13 August 2018

**Re: SECTION 4.55 (1A) MODIFICATION APPLICATION TO SSD 7751
BULLI HOSPITAL AGED CARE CENTRE OF EXCELLENCE
22 HOSPITAL ROAD BULLI**

This Modification Application has been prepared by TCG Planning on behalf of Health Infrastructure, seeking consent to modify various aspects of the SSD 7751 approval at 22 Hospital Road, Bulli (the subject site) pursuant to Section 4.55(1A) of the *Environmental Planning and Assessment Act, 1979* (EP&A Act).

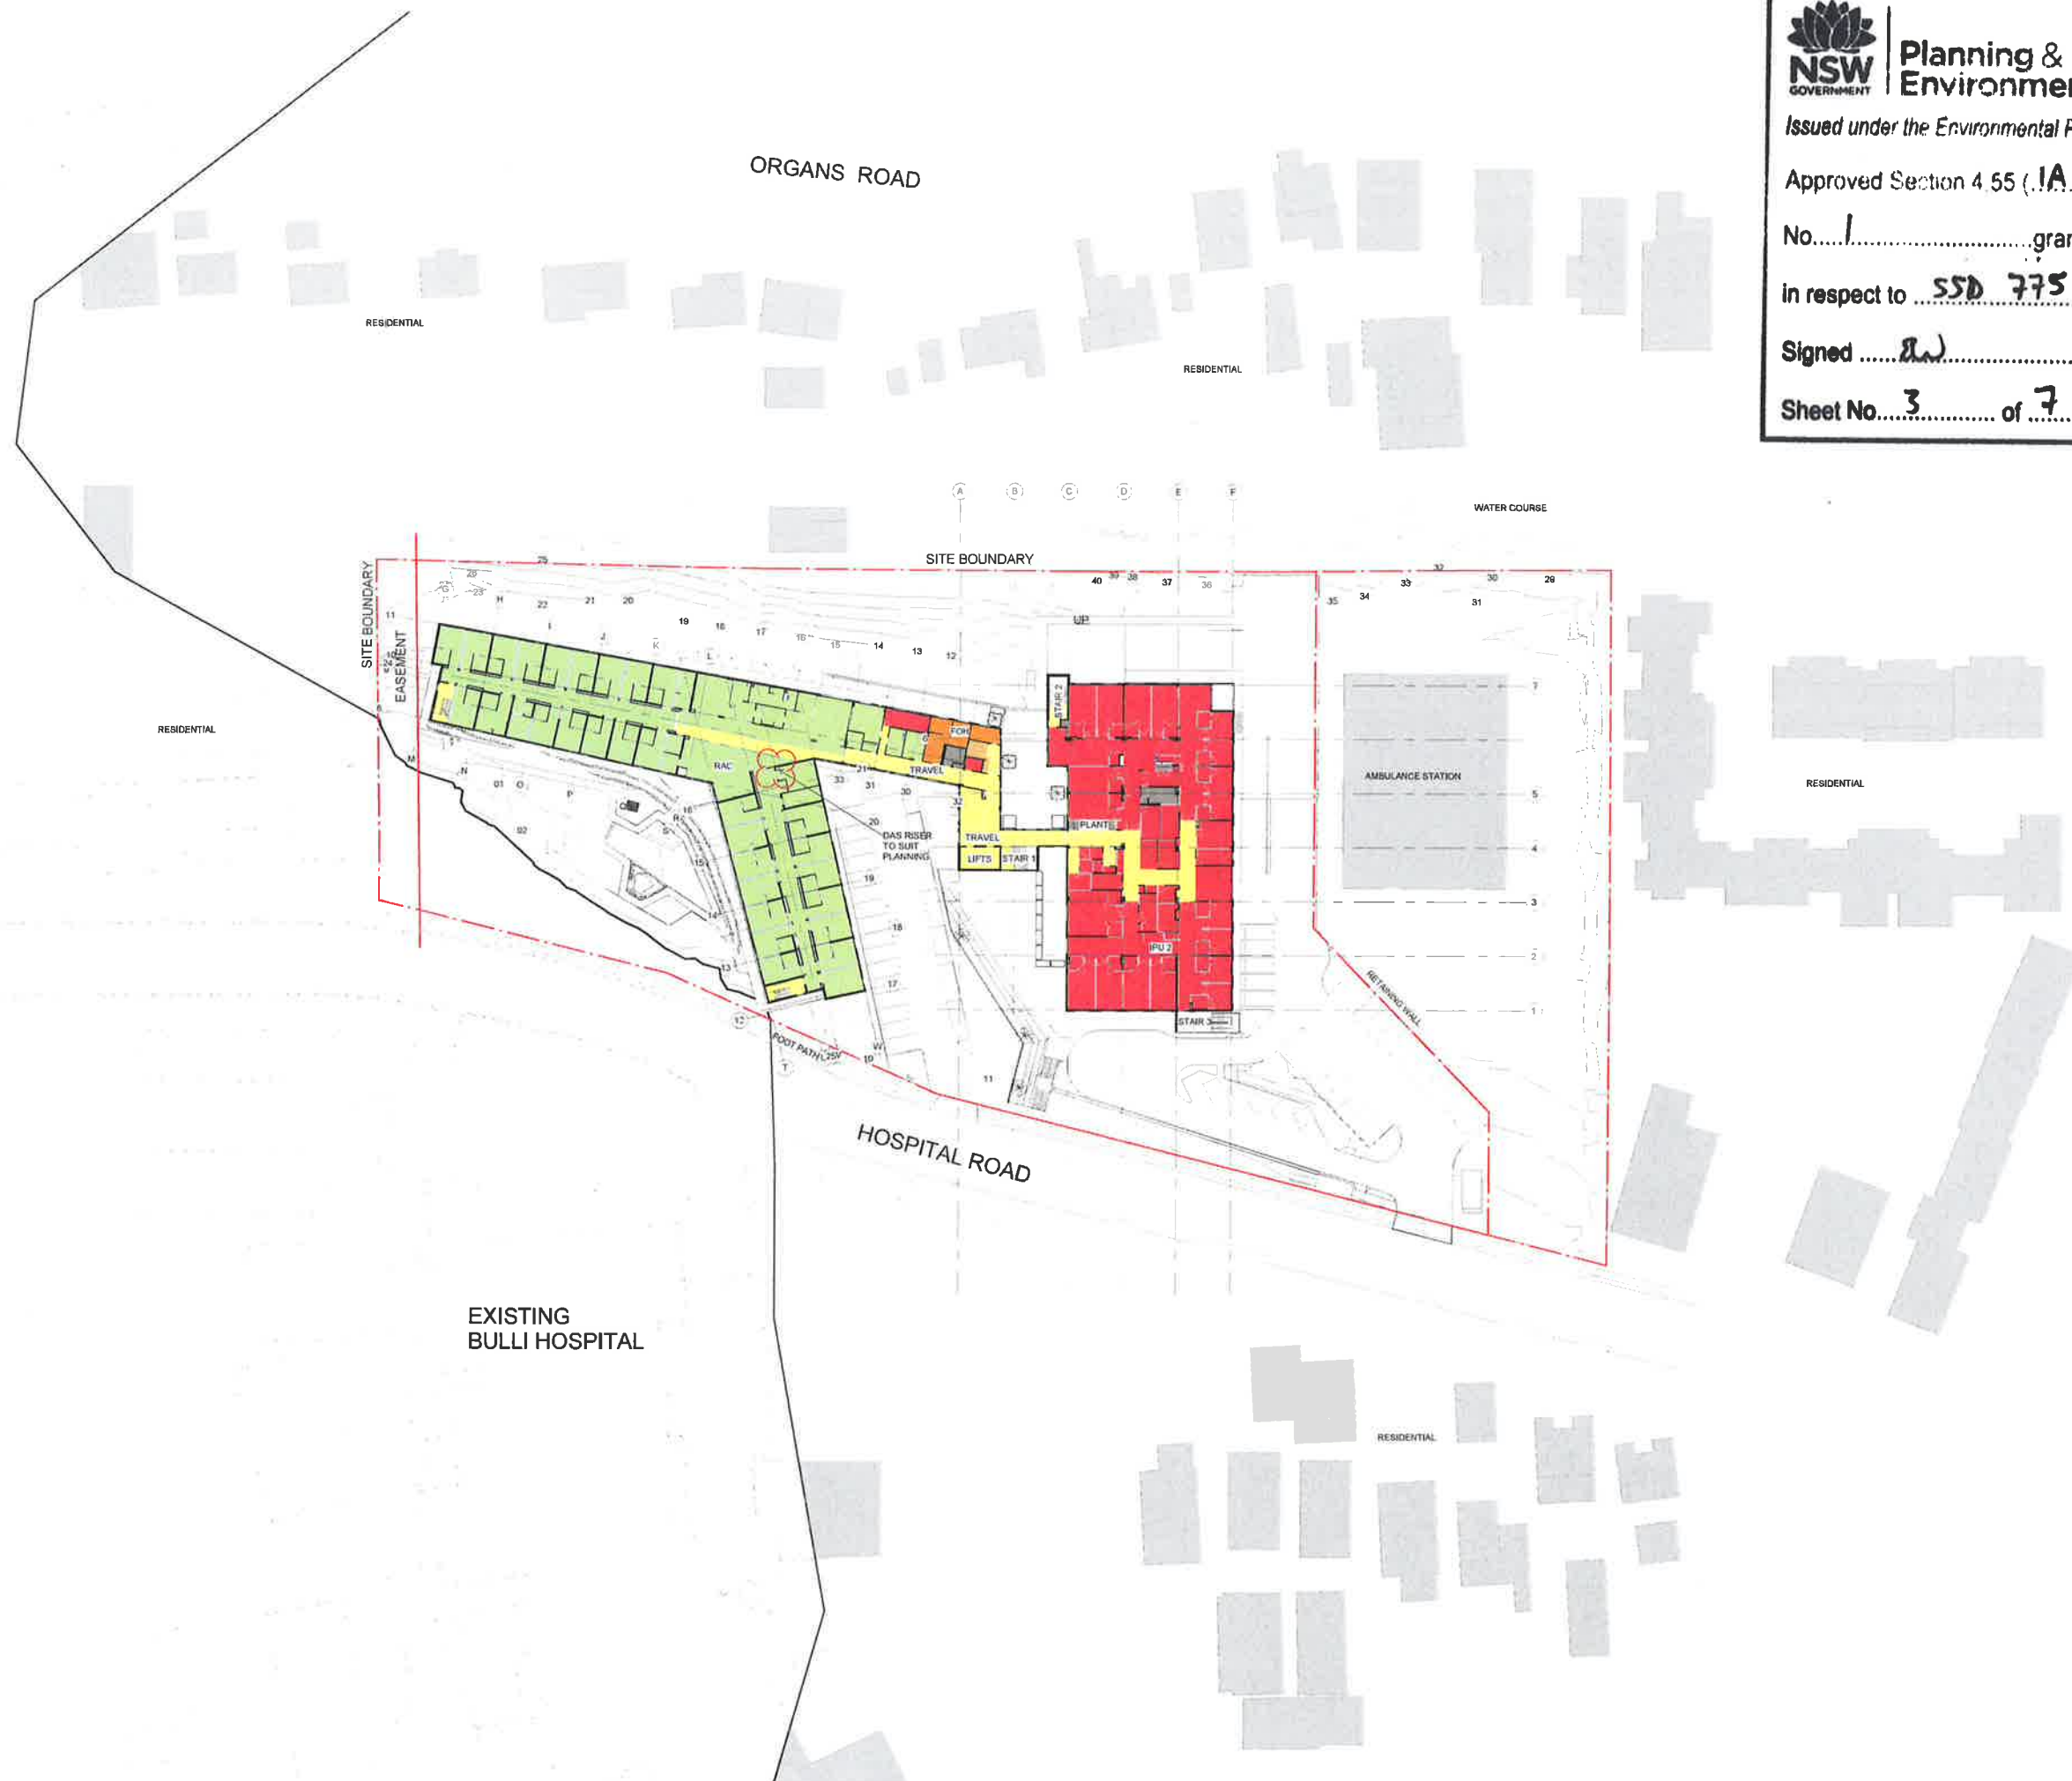
This modification to SSD 7751 consent seeks consent for various minor changes to the approved building layout to allow for the installation of a digital antenna system and the removal of Tree 11 which is now required to be removed as an approved retaining wall is located within the tree protection zone of this tree. These modifications are detailed below and illustrated in the revised Architectural Plans prepared Billard Leece Partnership Pty Ltd (Project 15617, dated 6/7/2018) listed earlier in this correspondence at **Attachment 2**.

The approved development required the retention of Tree No 11 (refer **Figure 6**), among other site trees, located close the Hospital Road frontage of the subject site. However, this tree is located directly adjoining the location of an approved retaining wall and stairway providing pedestrian access to the subject site. The tree protection zone for this tree is breached by this approved retaining wall and it is the opinion of the Arborist that this tree cannot survive this encroachment into its tree protection zone and therefore it should be removed. The Arborists report is at **Attachment 4**.
